Recommendation Report for Planning Permission for Works or Extension to a Dwelling

REF NO: BE/45/22/HH

LOCATION: 93 Addison Way
Bersted
PO22 9HZ

PROPOSAL: Single storey rear extension.

Proposed Rear Extension Planning
Date May 2022
Scale 1:50

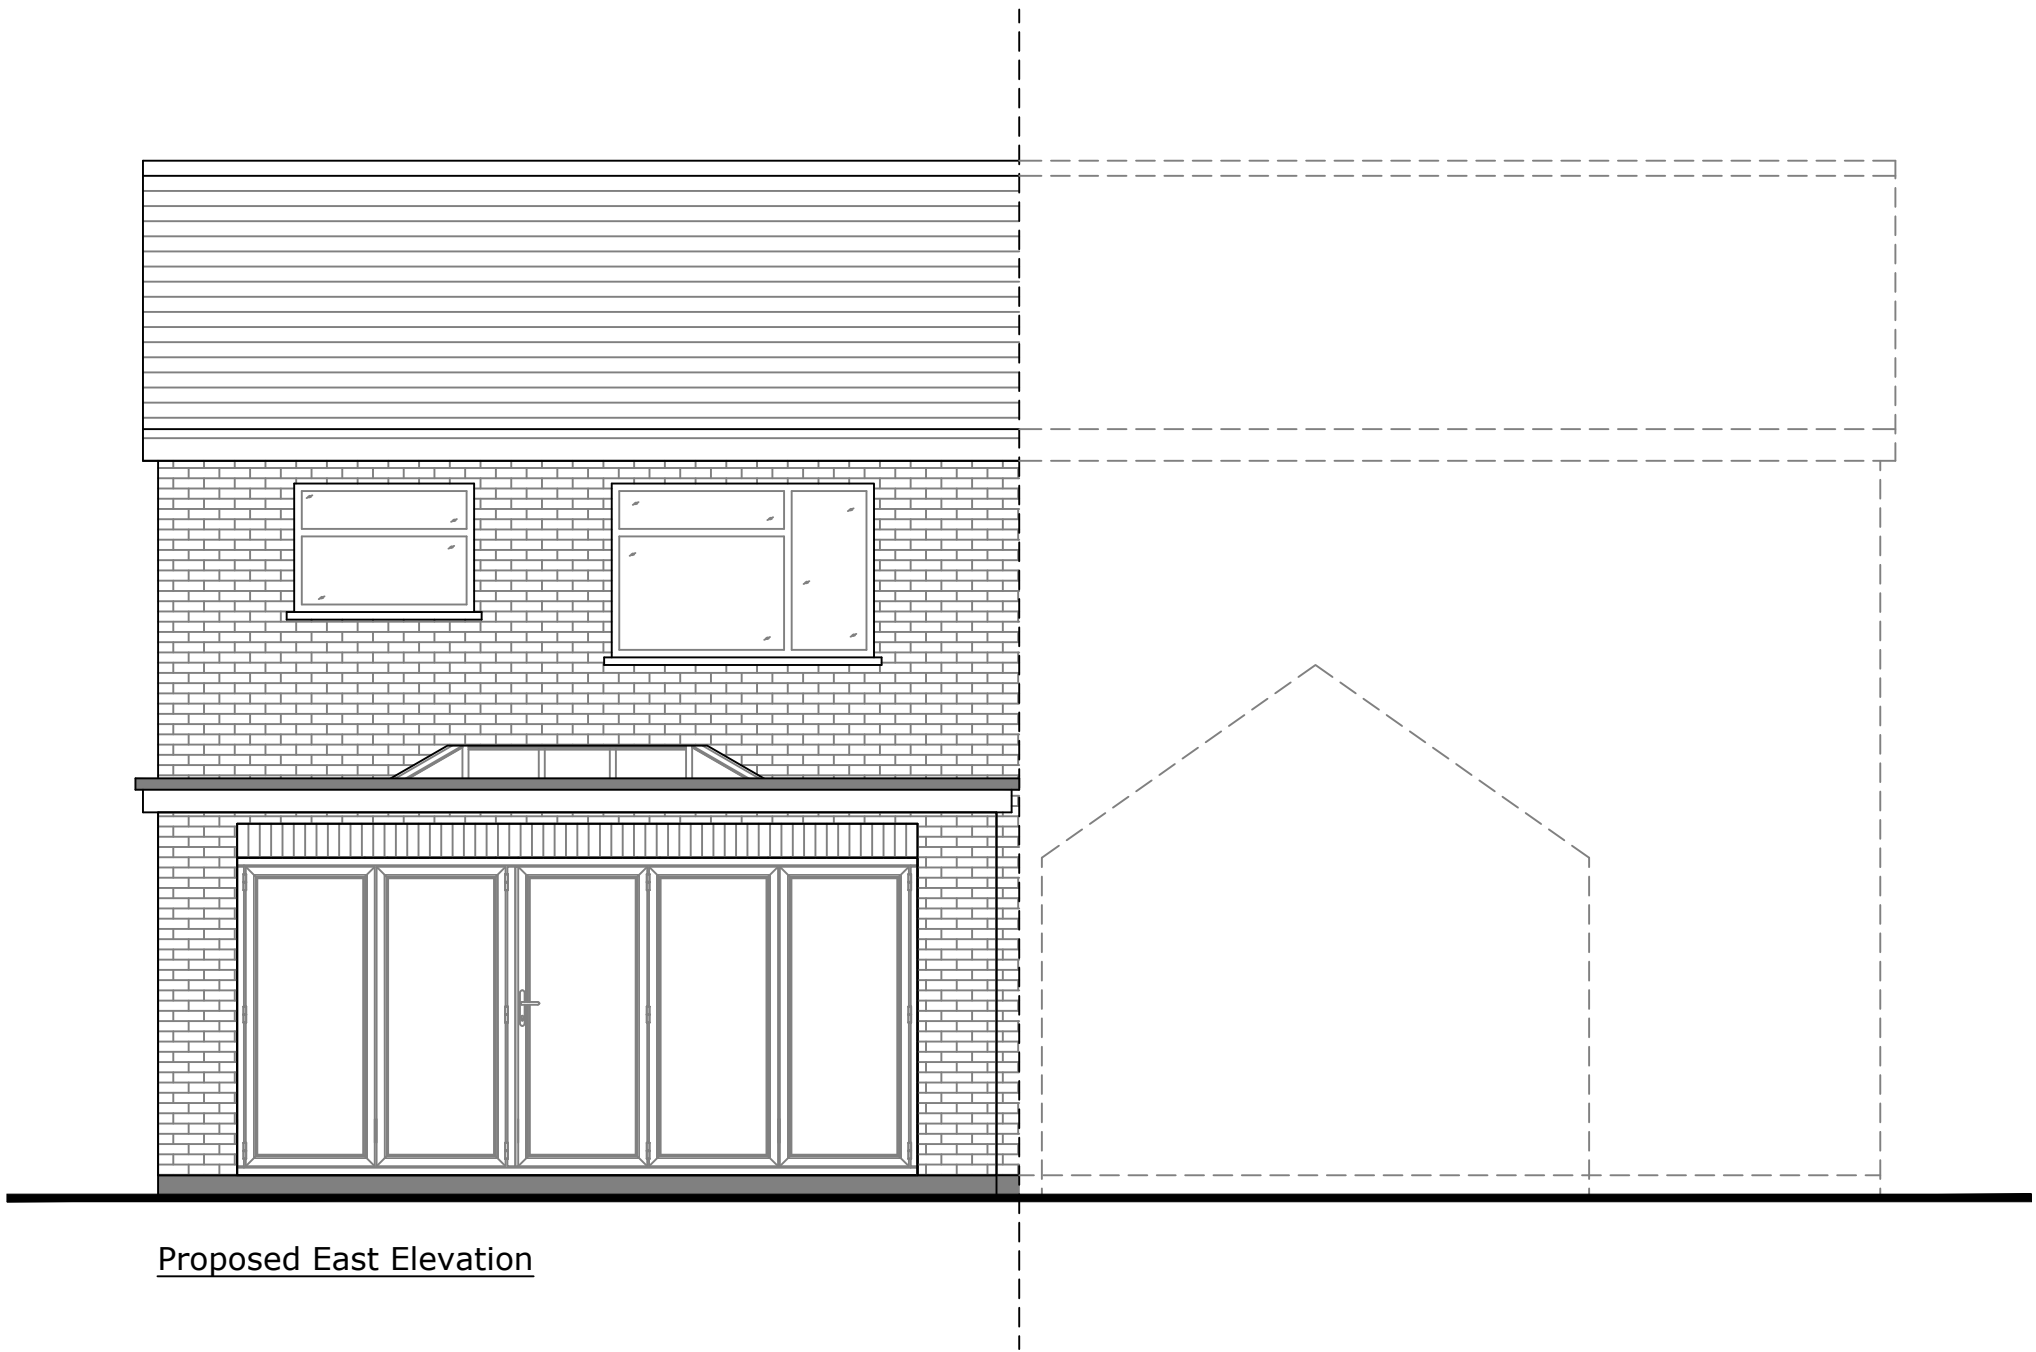
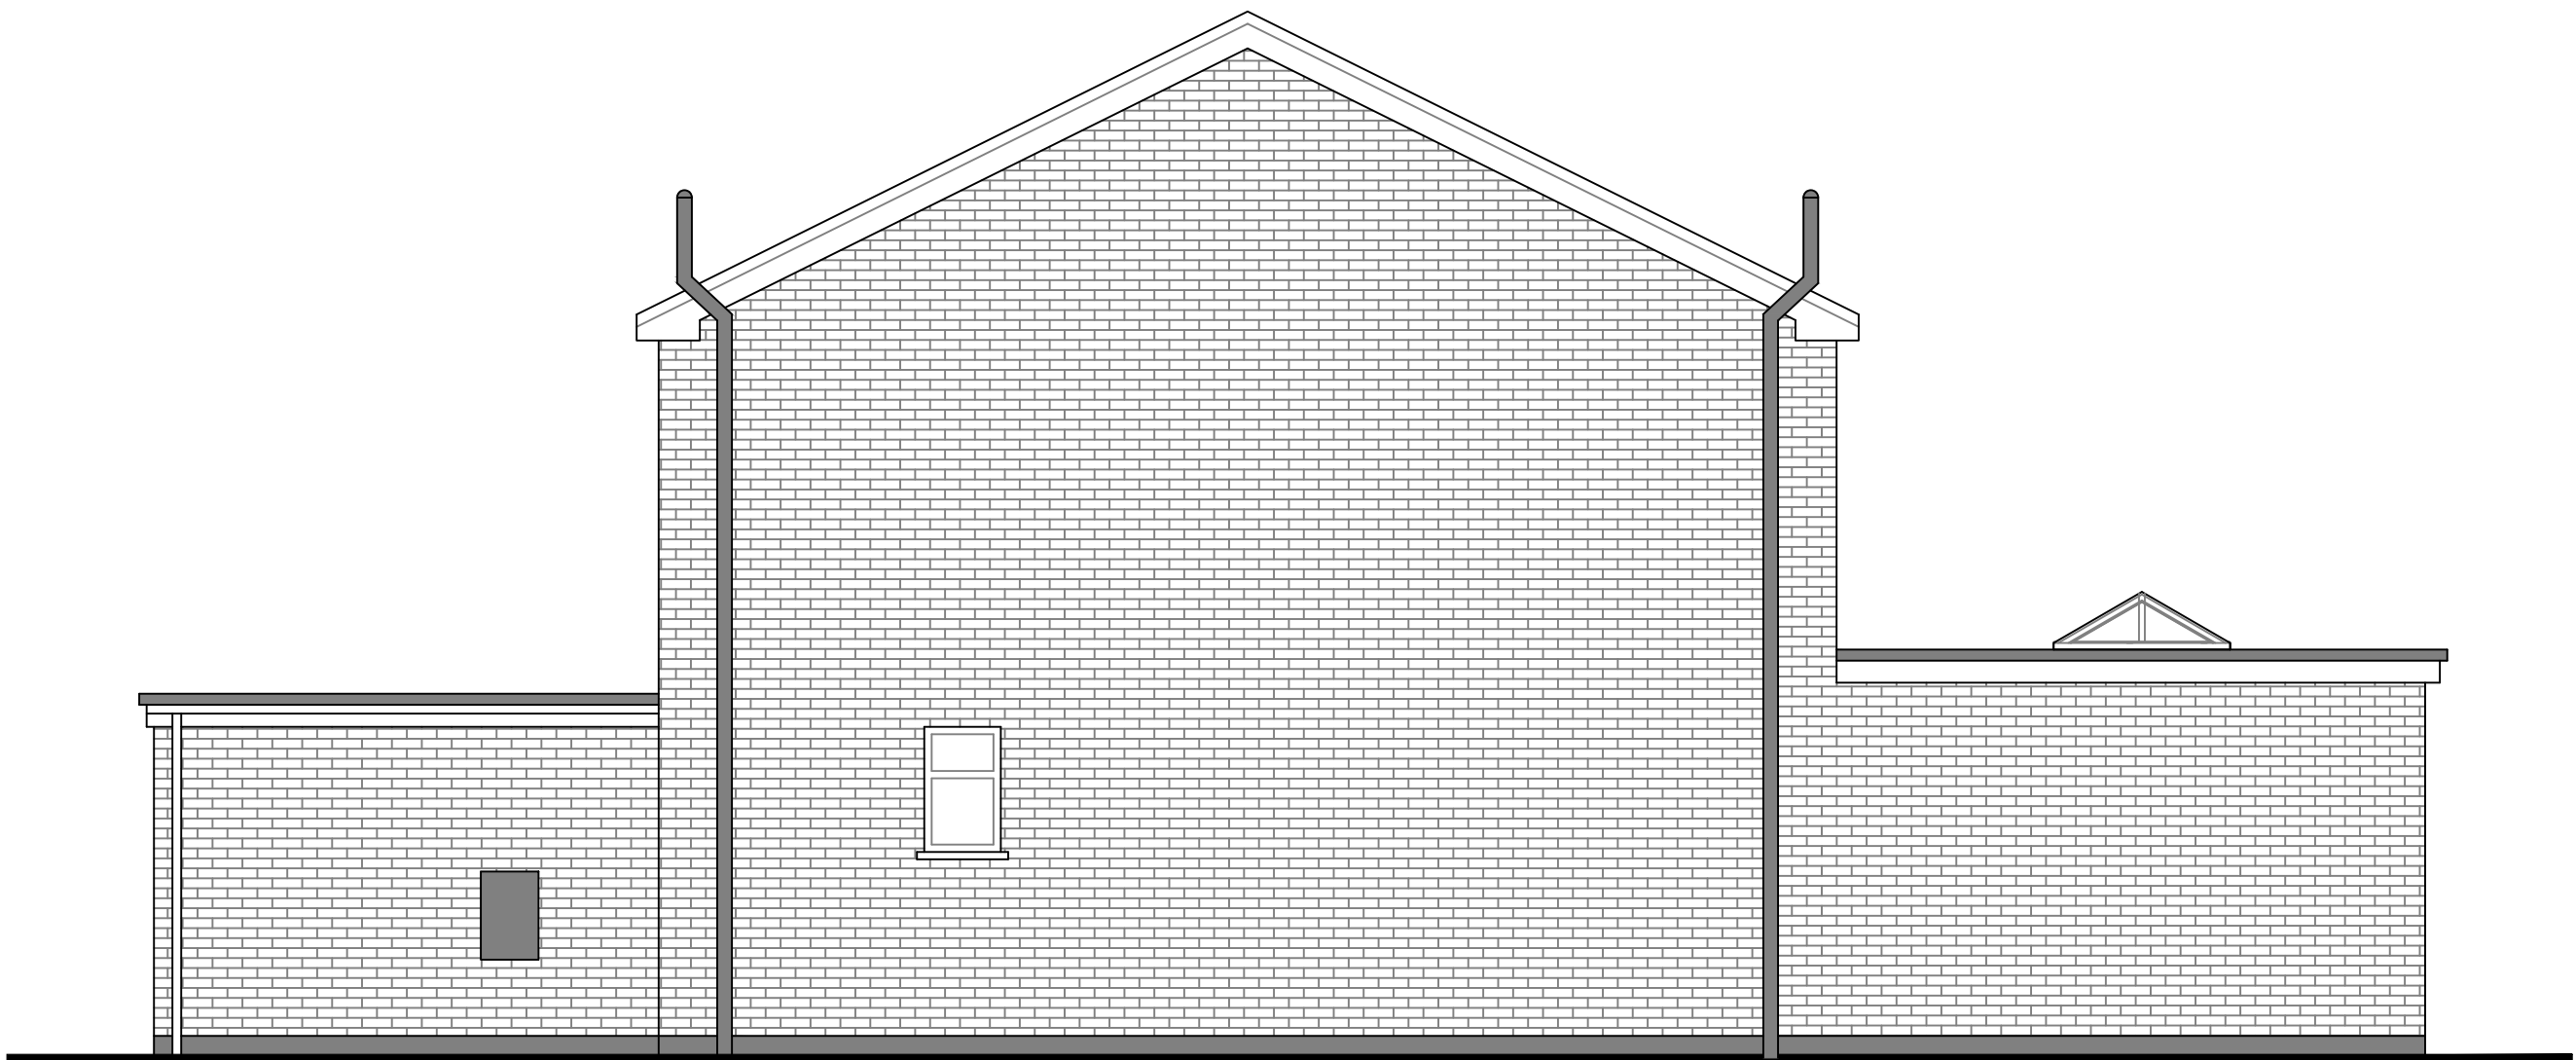
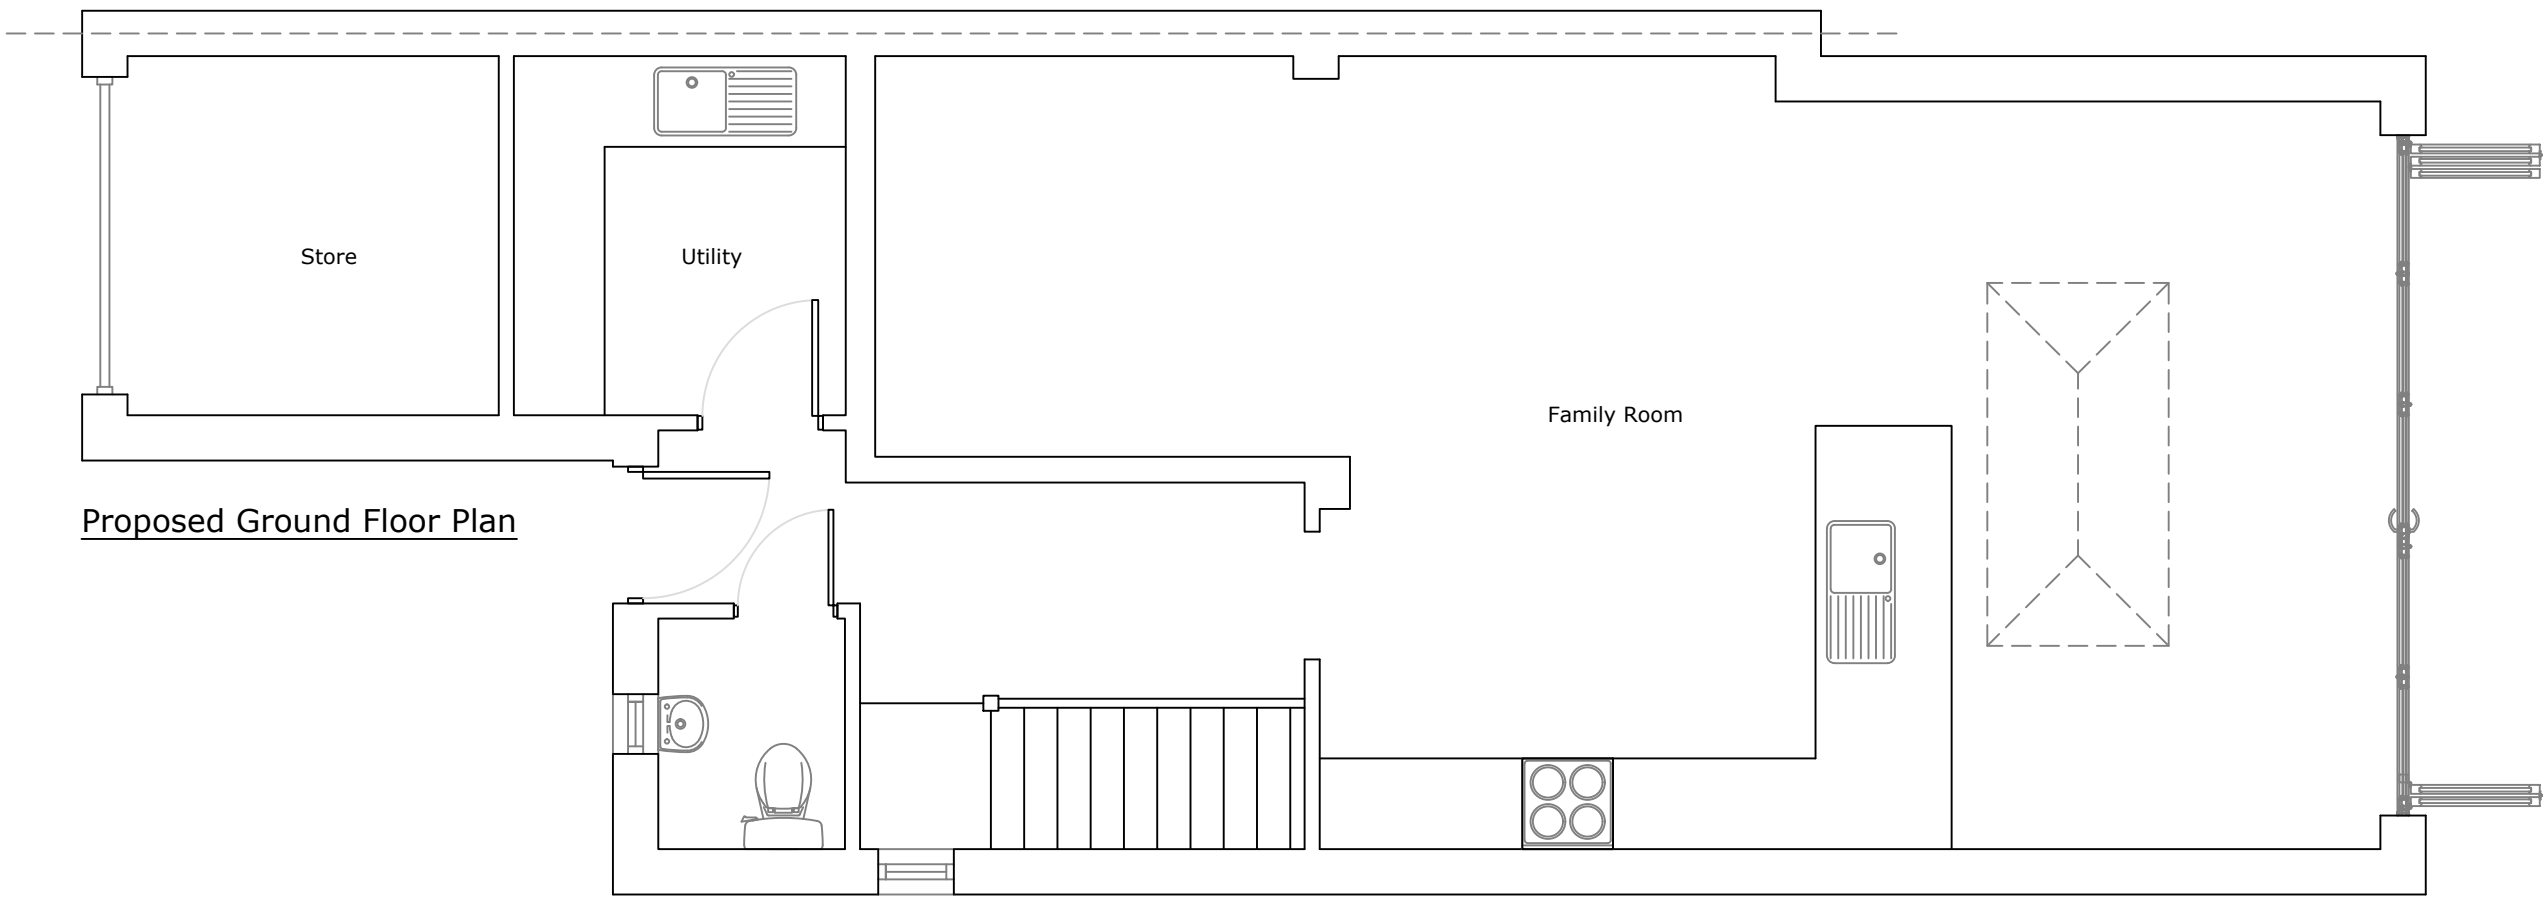
The extension is a modest size, and will project 4m from the rear elevation, with a width of 5.55m. It will have a flat roof, similar to that of the store to the front of the property, and will not appear unduly out of place in relation to the main dwelling. It is in keeping with the character of the property and will not have an adverse impact on its visual appearance. Being to the rear, the proposal will not be visible from the street scene and will have no impact on the composition and appearance of the street. It is in keeping with the character of the area and will have minimal impact on visual amenity.

The extension is single storey and will have a flat roof at a height of approximately 2.75m. This roof will incorporate a roof lantern which will protrude slightly above at around 2.98m but will have no impact on residential amenity. The proposal will retain 0.15m to the north boundary, 22.565m to the east, and 1.1m to the south. These distances are in accord with D DM4 of the Arun Local Plan and are acceptable. Although close to the boundary with No.92, the extension will only project marginally further than the neighbouring rear extension and will have minimal impact on their residential amenity. It does not conflict the 45- or 60-degree rules and will not result in adverse overbearing or overshadowing.

The extension will feature a set of folding doors to the east (rear) elevation. These doors will face into the garden and will not overlook any neighbouring properties. They pose no risk to residential privacy or amenity and are acceptable.
